Development Control
Ribble Valley Borough Council

App no: 25.0213

Address: Duke of York Inn Grindleton Brow Grindleton

Proposal: Approval of details reserved by conditions 3 (walling and roofing materials), 4 (specifications of proposed windows and doors), 5 (conservation roof lights), 6 (boundary treatments), 7 (archaeological investigation), 8 (lighting), 10 (parking and turning), 11 (landscaping), 12 (biodiversity gain plan) and 13 (habitat management and monitoring) of planning permission 3/2024/0439.

Landscaping plan to discharge condition 10
from application 3/2024/04/39

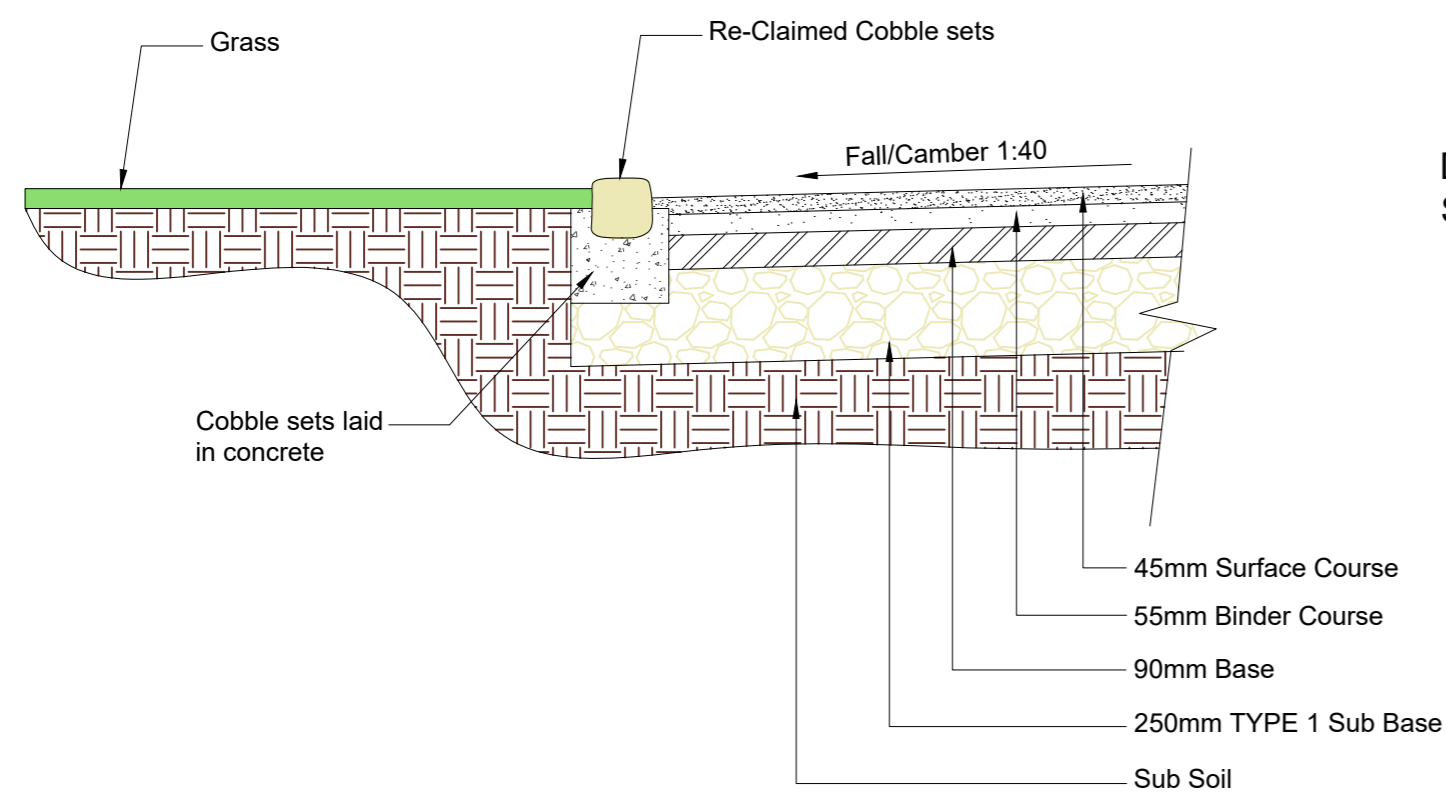
Condition 10 (parking and turning) – There is no objection to the discharge of this condition.

**Landscaping plan with boundary treatments to discharge condition 6 and 11 from Planning Consent 3/2024/0439 and condition 6 on Listed Building Consent 3/2024/0440**

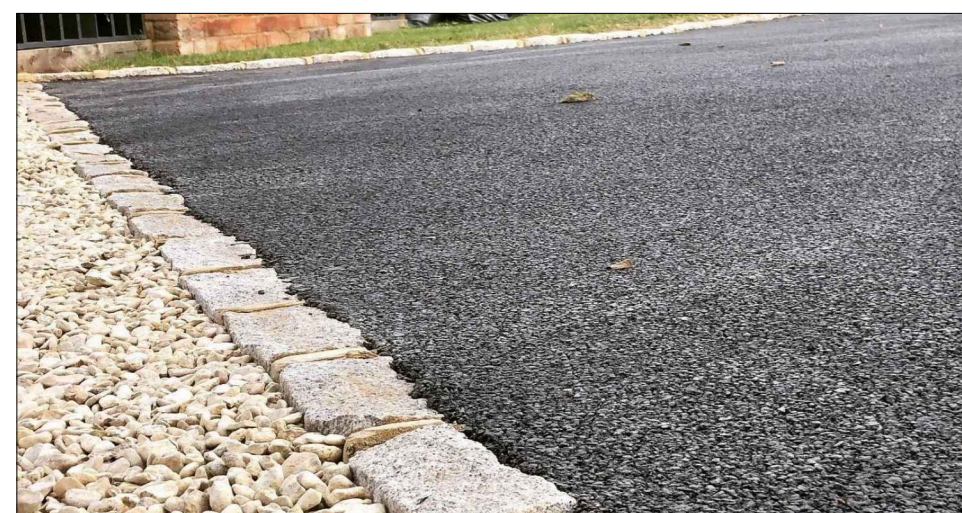
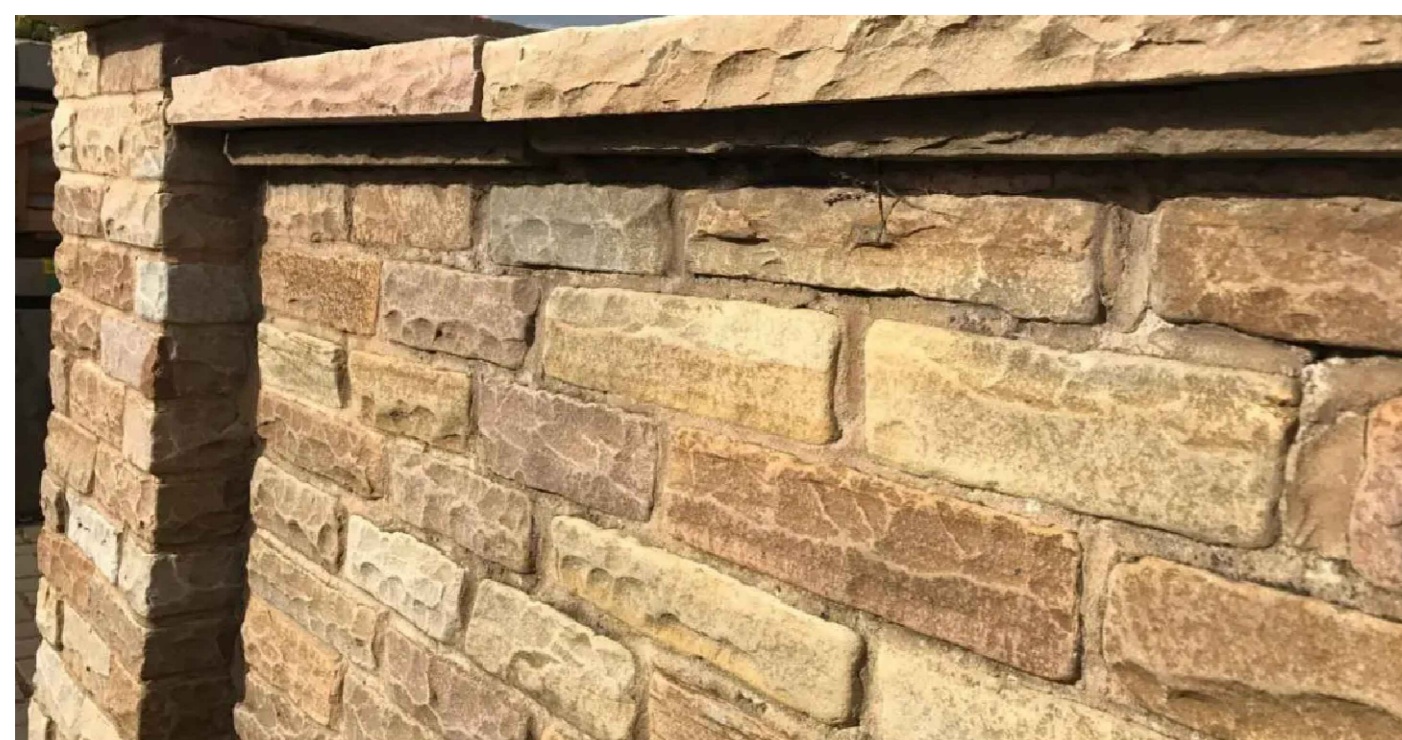
Condition 6 (boundary treatments) – The 1.2m high stone wall needs to be lowered to 1m high along frontage within the visibility splays. Subject to this there is no objection to the discharge.
